**Transport Comments**

Upper Heyford Former Airbase – Proposed settlement of 1075 dwellings with associated works and facilities including employment uses, playing fields, school and other infrastructure.

PROPOSED BUS ROUTE & STOP LOCATIONS

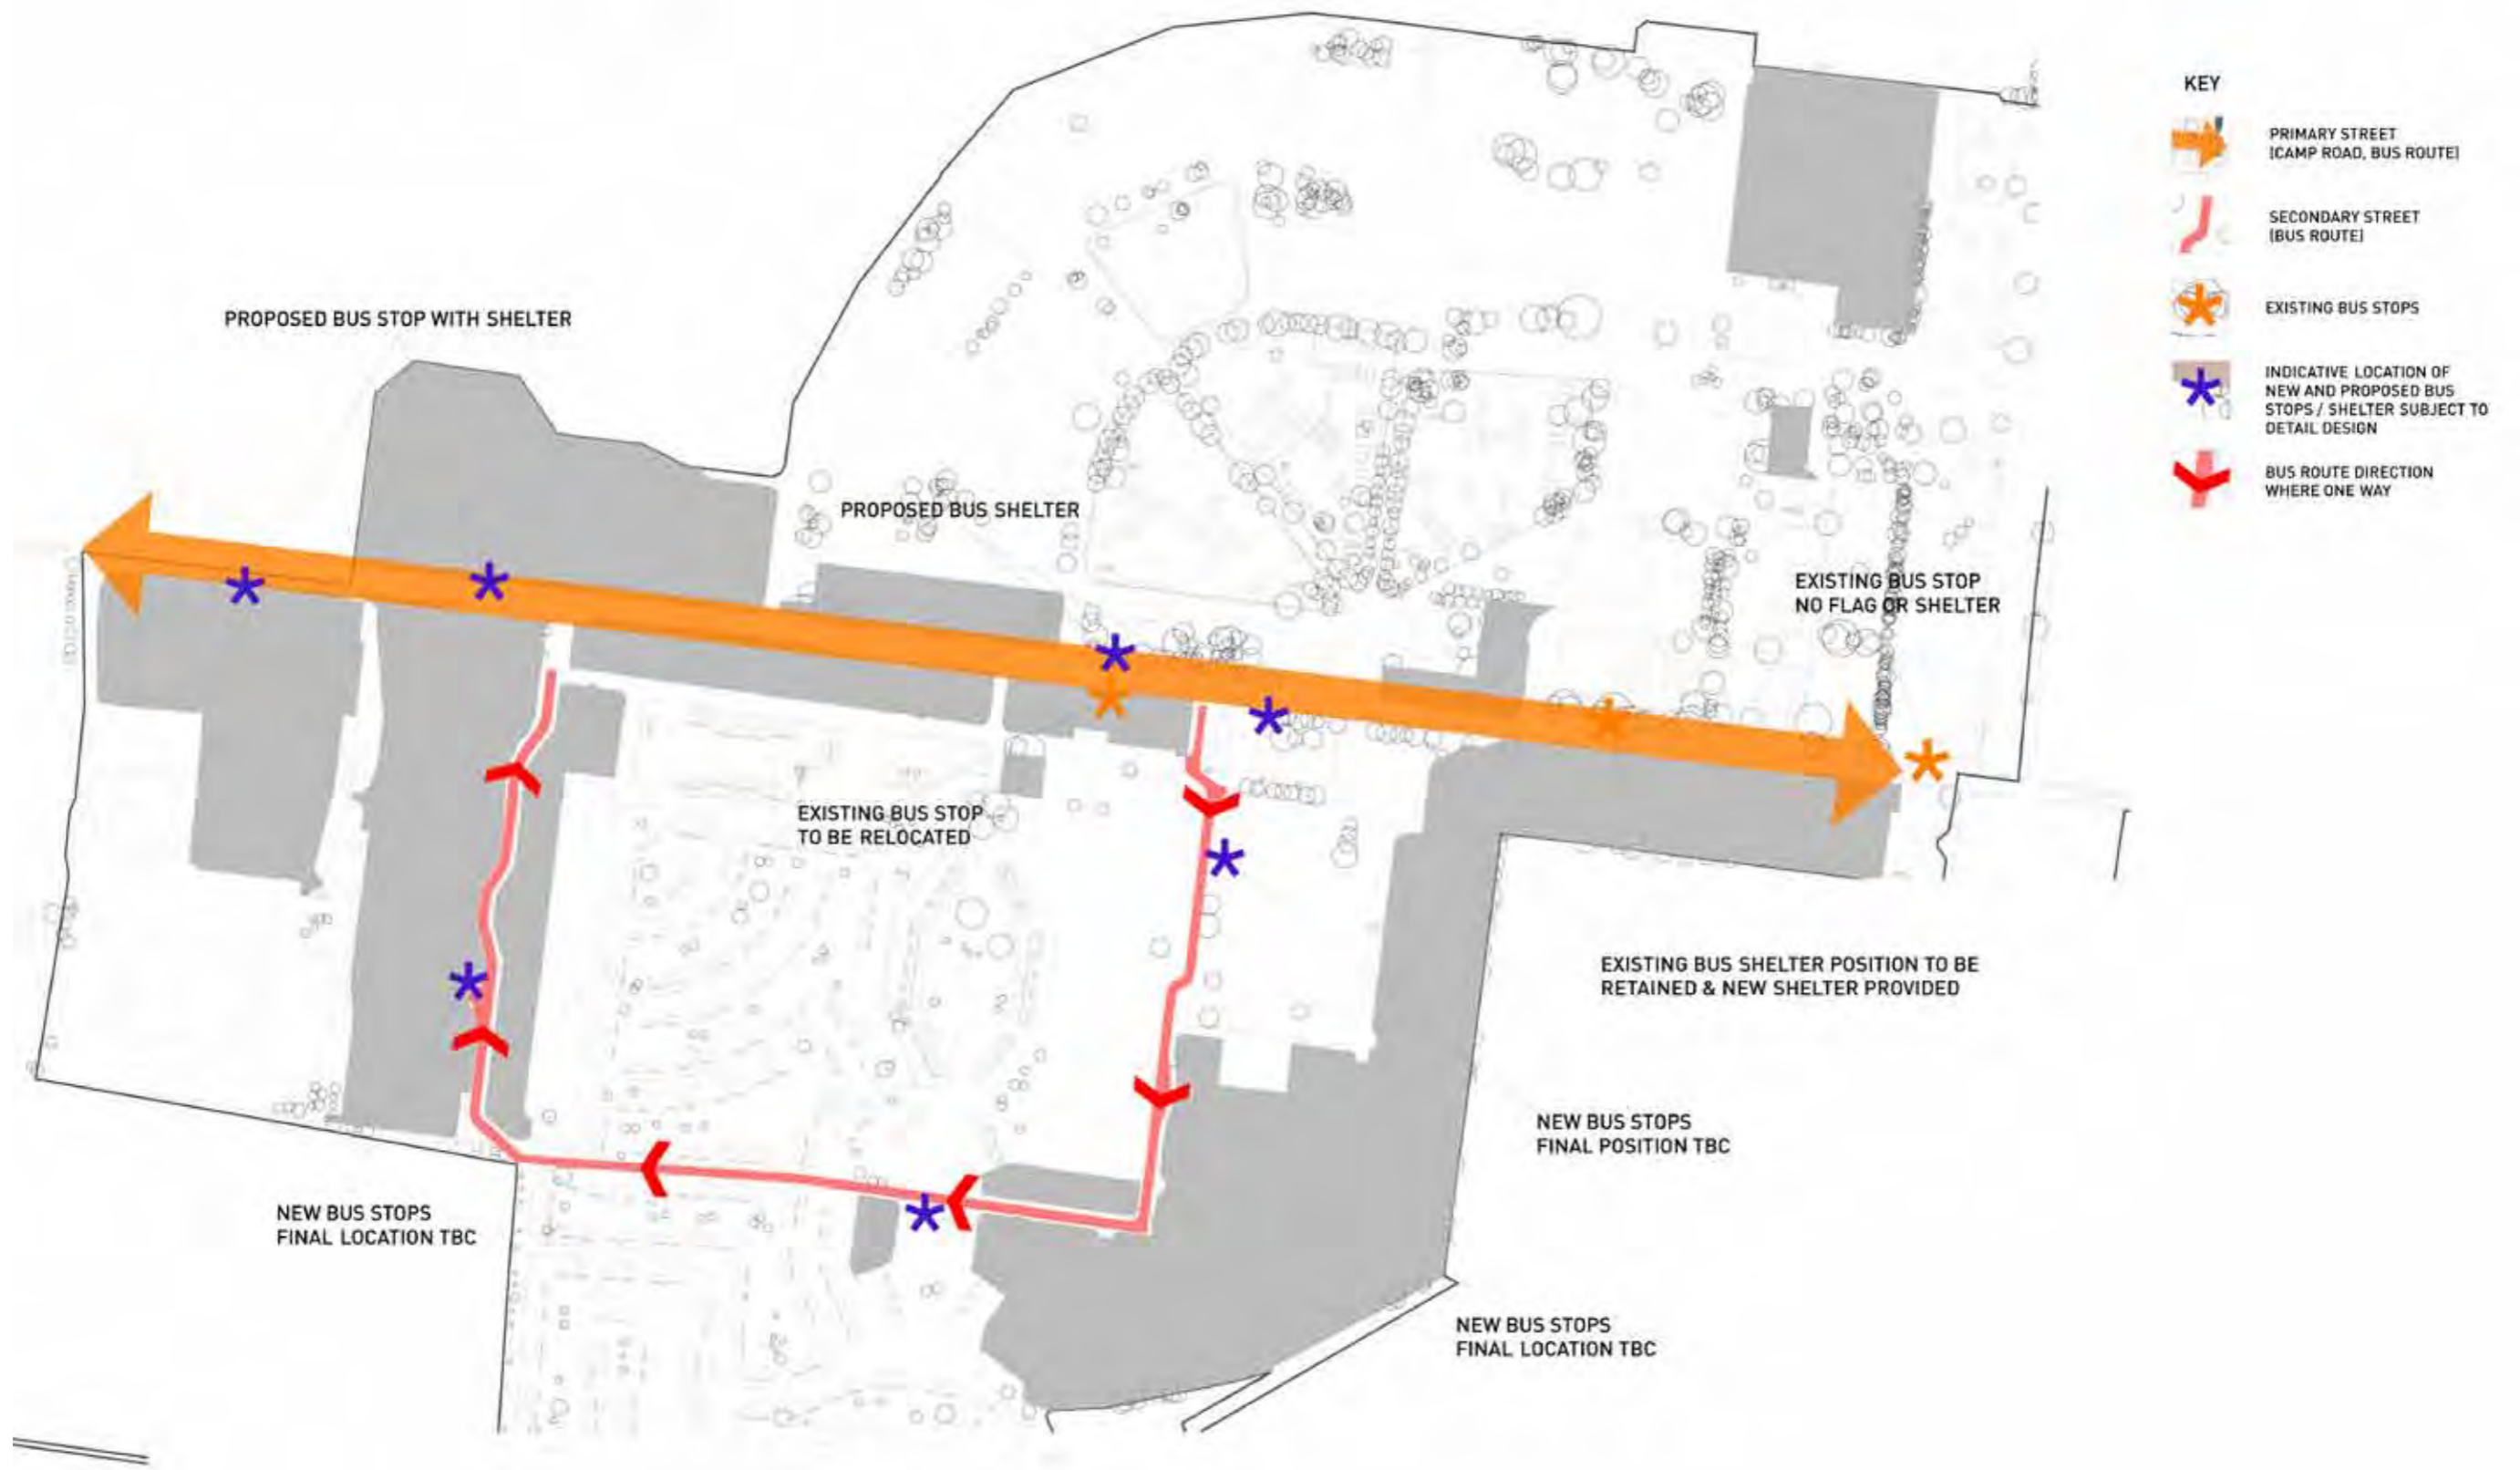
Bus Routes: a bus route is indicated which provides the facility to turn buses and to get bus stops closer to dwellings. The route indicated uses streets which are too narrow although the bus would be able to navigate the road if designed features were added. More details will be required to develop this route into a workable solution.

**Bus Route:** details to be submitted for the route for buses around site to provide turning of the bus for the out and back service to Bicester or to provide a turning facility close to Camp Road whilst ensuring that bus stops are placed to get as many dwellings within the shortest walking distance as possible. The bus route must be designed to the County Councils standard for adoption for buses to be able to use the route. Details will include all bus stop facilities.
